Project: Prince of Wales Hospital
Randwick NSW Comprehensive
Cancer & Blood Disorder Centre
Responses to Submissions – Traffic
Stage 1 Development

Reference: 223921

Prepared for: NSW Health
Infrastructure

Revision: 2

Figure B1 – Medium Rigid Truck movement at Gate No 6 and inside the car park south of the Heritage Gate

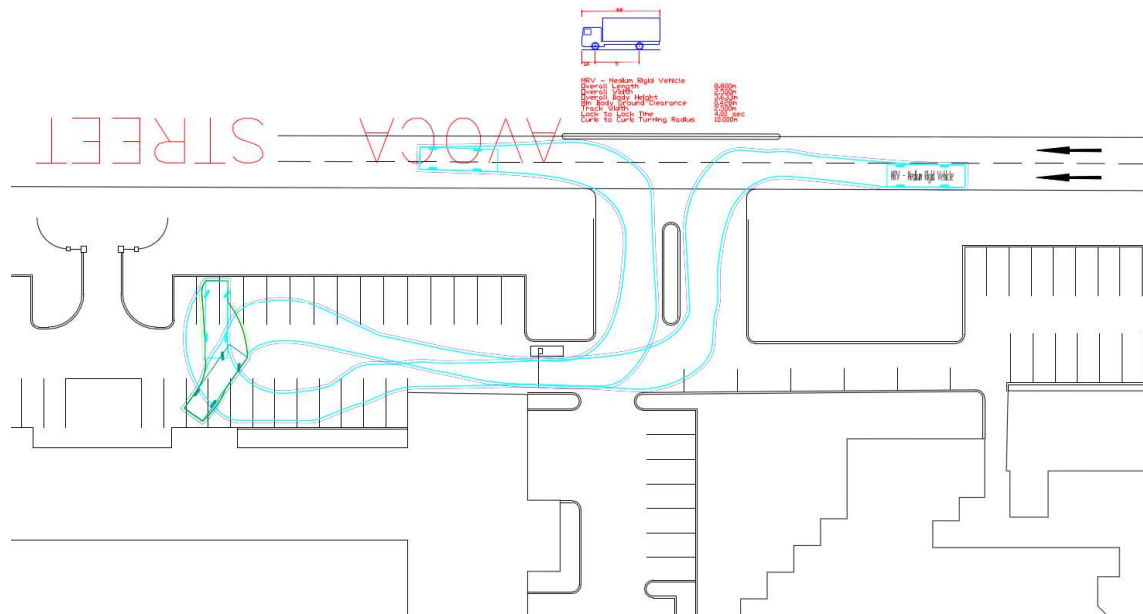
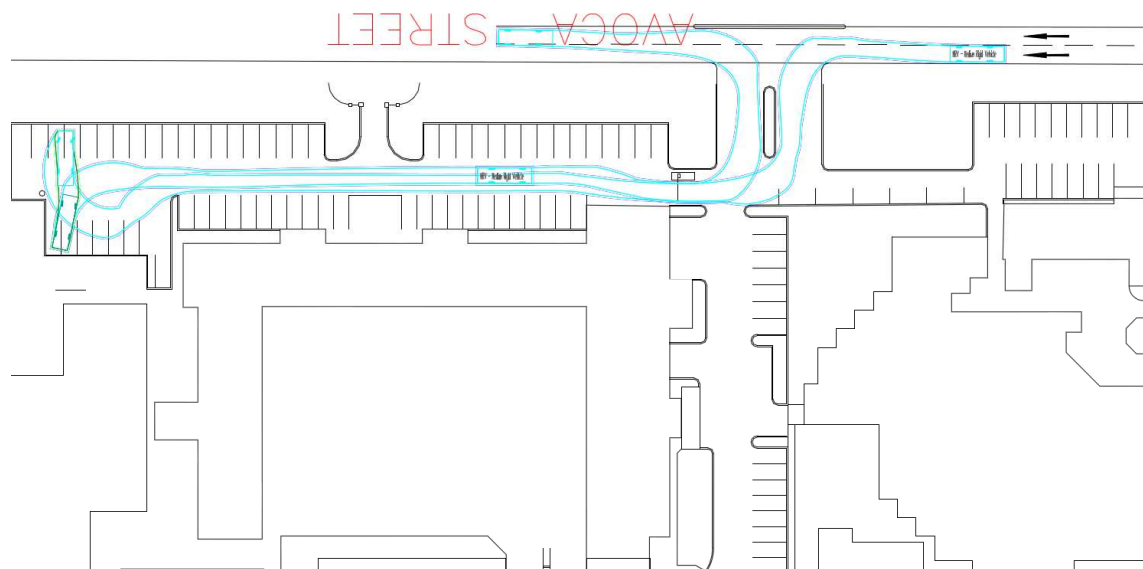
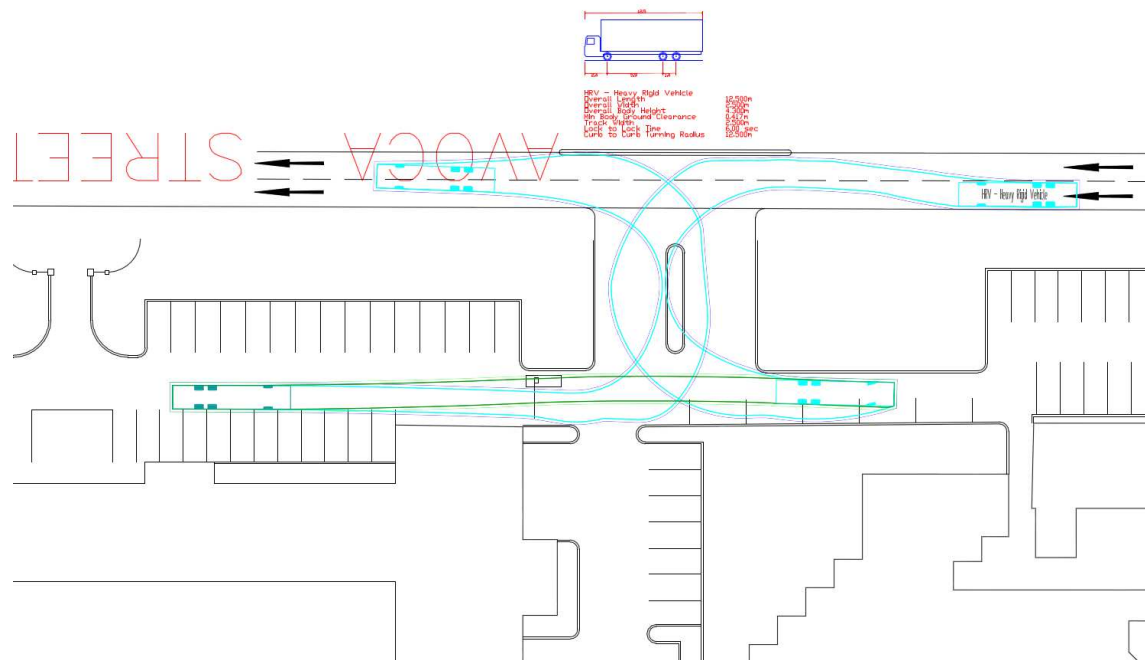
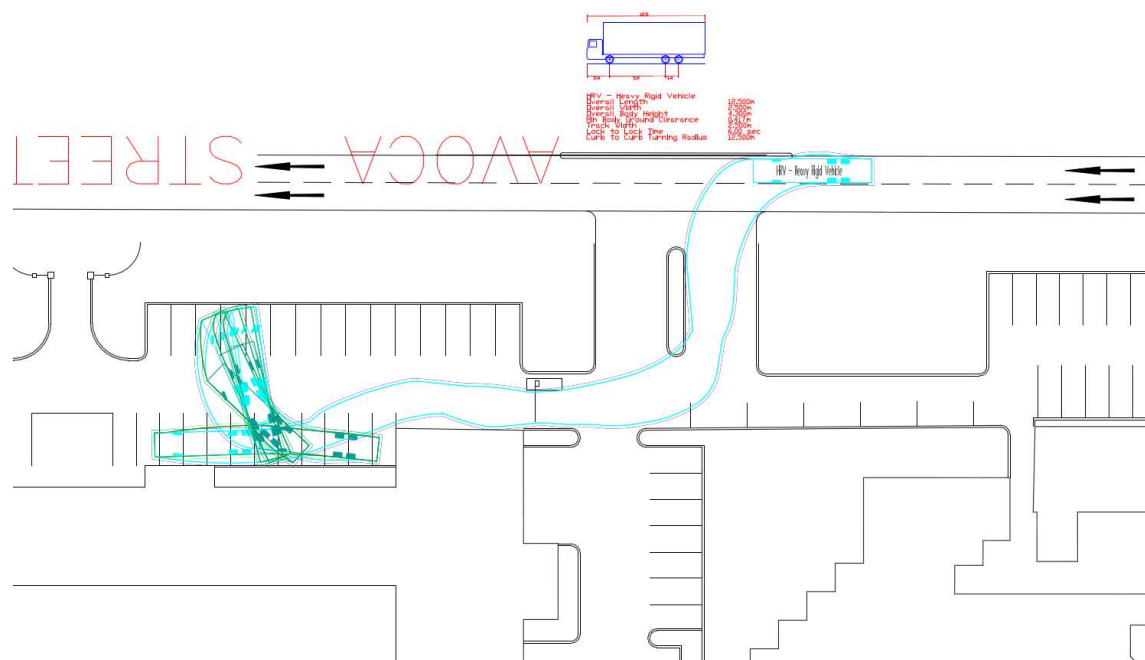
Issues Raised By	Issues Raised	Proponent's Response
Roads and Maritime Services	During construction it is noted that conflict will exist between vehicular traffic and pedestrian at Gate No. 6. Measures need to be implemented to minimise the potential of crashes occurring. Similarly the re-direction of pedestrians to other areas needs to be examined for the provision of appropriate infrastructure to cater for their movement.	<p>A detailed construction traffic management plan and traffic control plan will be prepared prior to commencing the construction works and submitted for RMS' approval.</p> <p>With regard to catering for pedestrian movements, the following measures will be provided.</p> <ul style="list-style-type: none"> • A dedicated pedestrian path will be provided from Gate 6 to link up with the existing pedestrian network within the Hospital Campus as per relevant standards • Pedestrian paths will be protected using the RMS approved water filled barriers where pedestrians paths are provided adjacent to construction vehicle paths • RMS certified Traffic controllers will be in place to manage traffic and pedestrian movements when construction vehicles accessing the site via Gate No 6. • Adequate signs will be posted to re-direct pedestrians to access either High Street access or Gate No 6. • No construction vehicles are allowed to either reverse into, or reverse out of, the site at Gate 6. • Any reversing manoeuvres of construction vehicles within the Hospital Campus will be supervised by RMS certified traffic controllers
